Re: Planning Application 20/0215

Address: The Newdrop Stoneygate Lane Ribchester PR3 2XE

Description: Conversion of Public House to five dwellings.

Director of Highways and Transport
Lancashire County Council
PO Box 100 · County Hall · Preston · PR1 0LD
www.lancashire.gov.uk

Proposed Site Plan  
scale 1:200

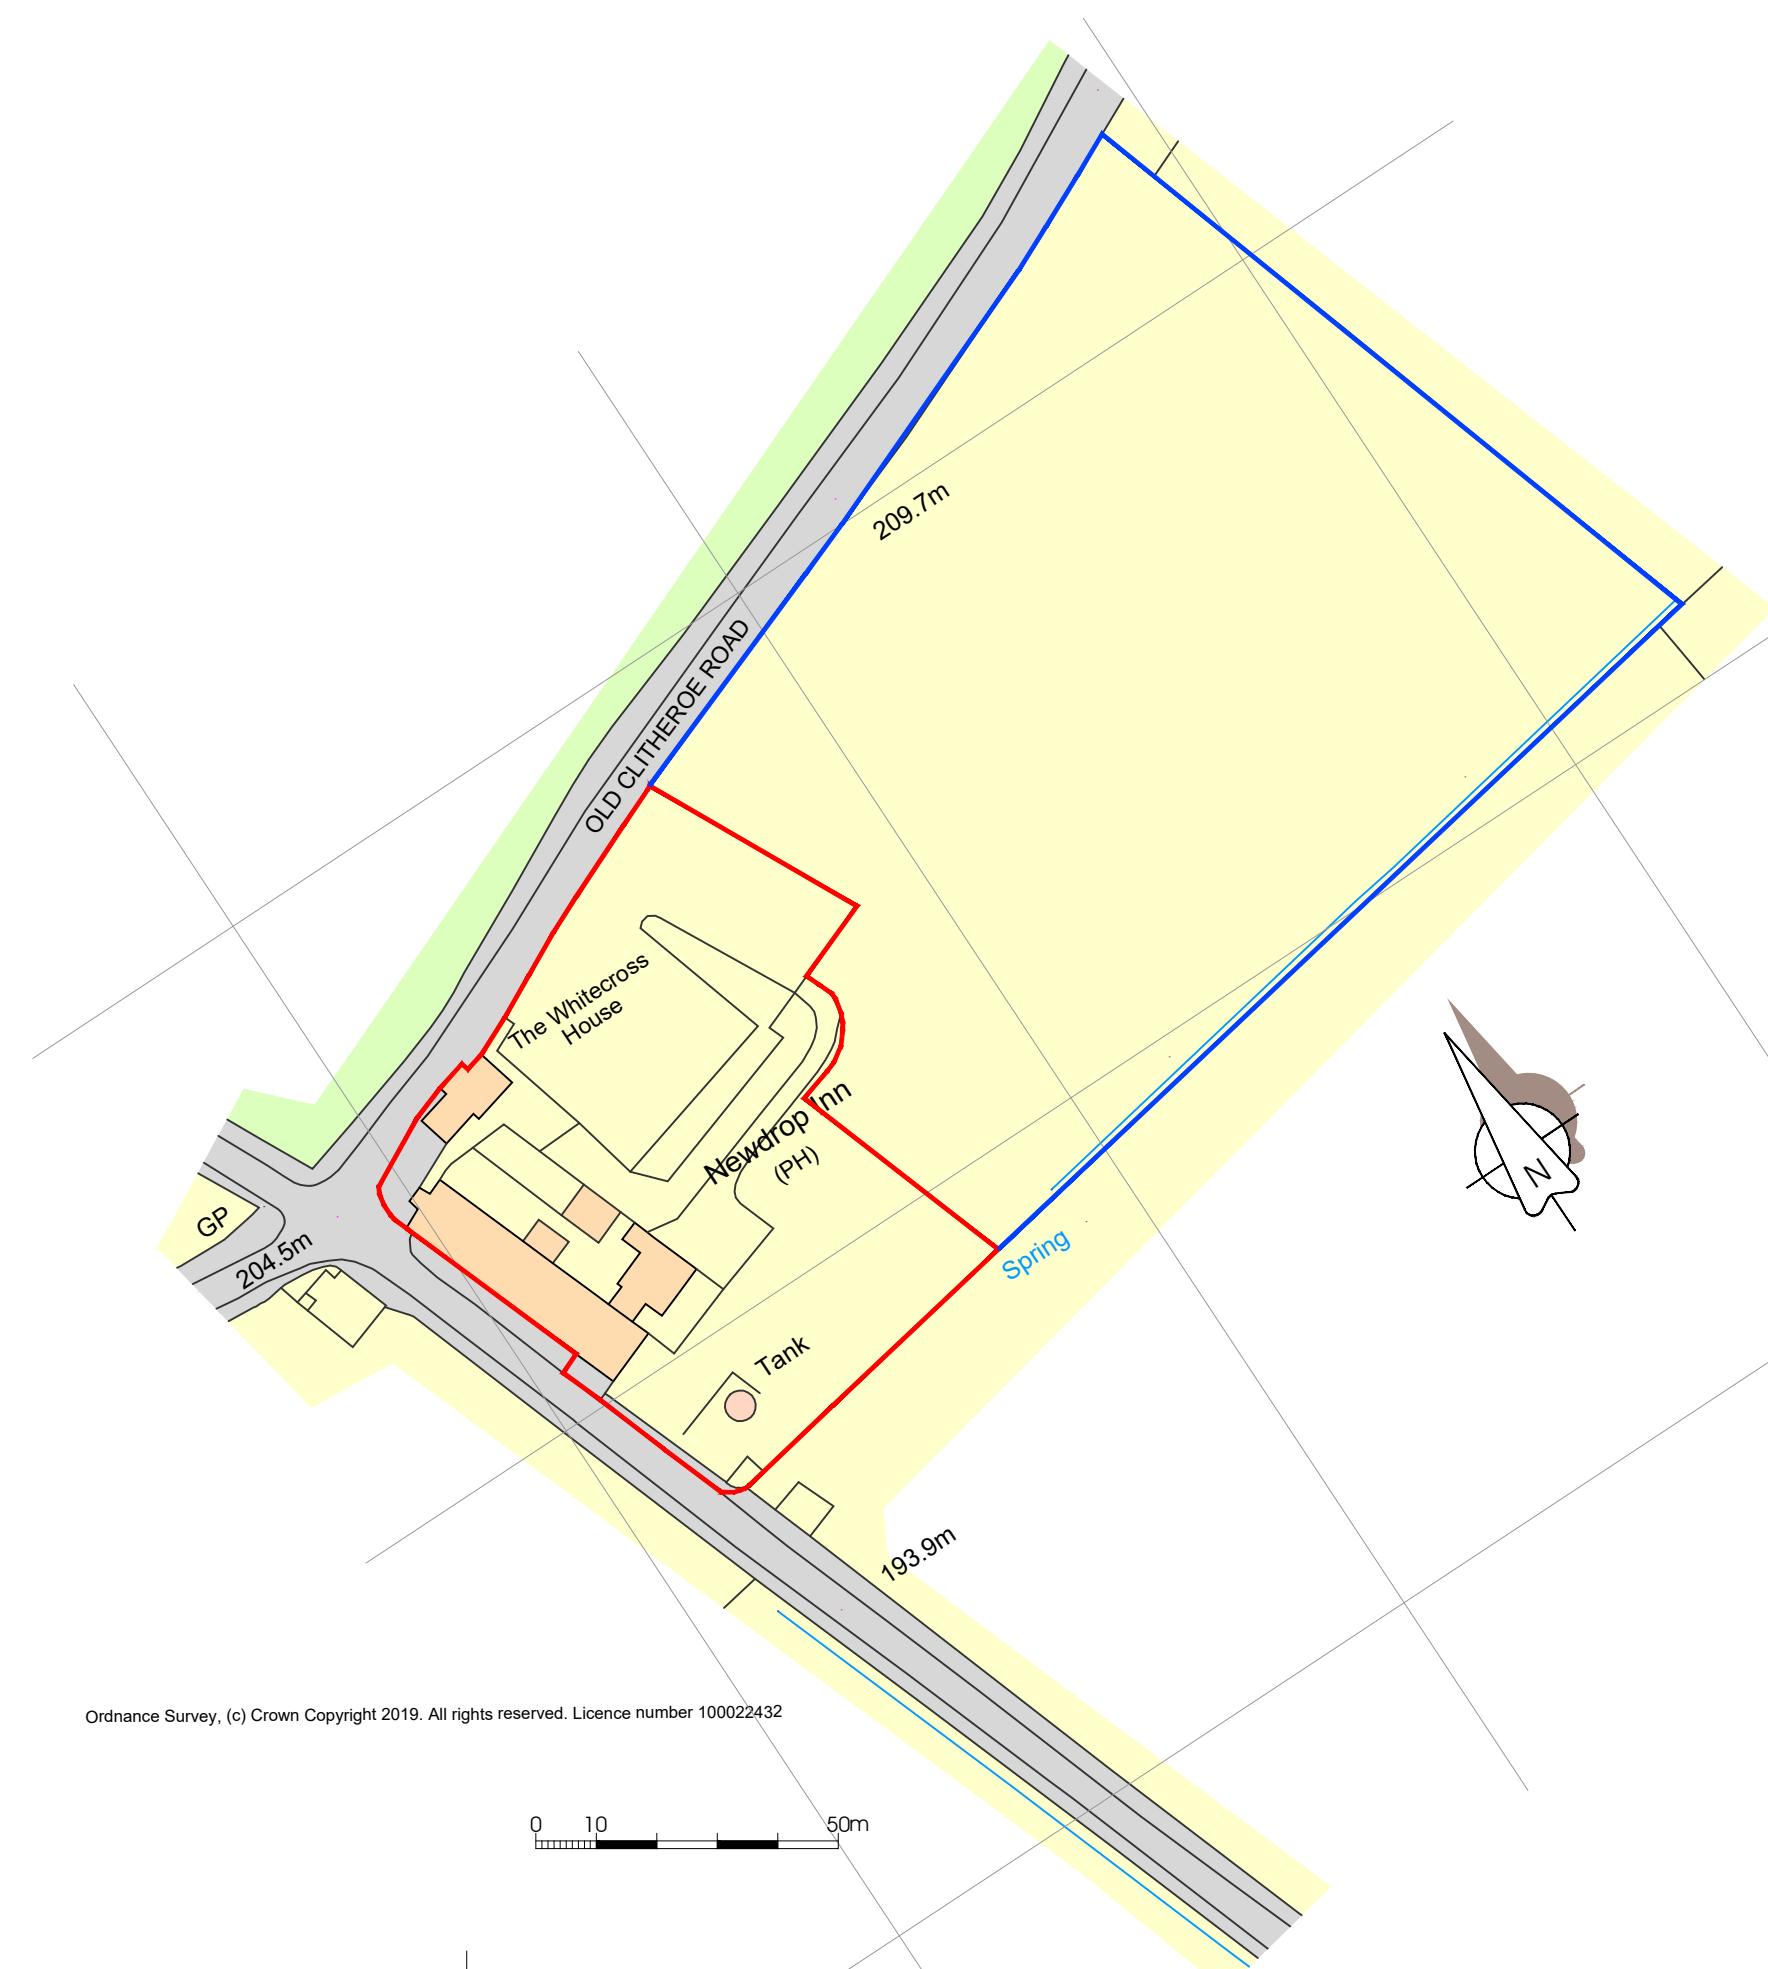
There is a concern regarding the parking provision for dwelling 1, the area proposed is adopted highway, and as such this cannot be designated as residential parking. An alternative position for the off street parking should be sort, a suitable pedestrian link will also need to be provided.

Whilst a visibility splay for the parking provision for dwelling 4 has been shown the full extents of the splay have not been shown. In order to support this we would look for an automated 7 day traffic count to be provided so that the 85th Percentile speeds of the traffic can be accessed from which the extents of the required visibility splay can be found.
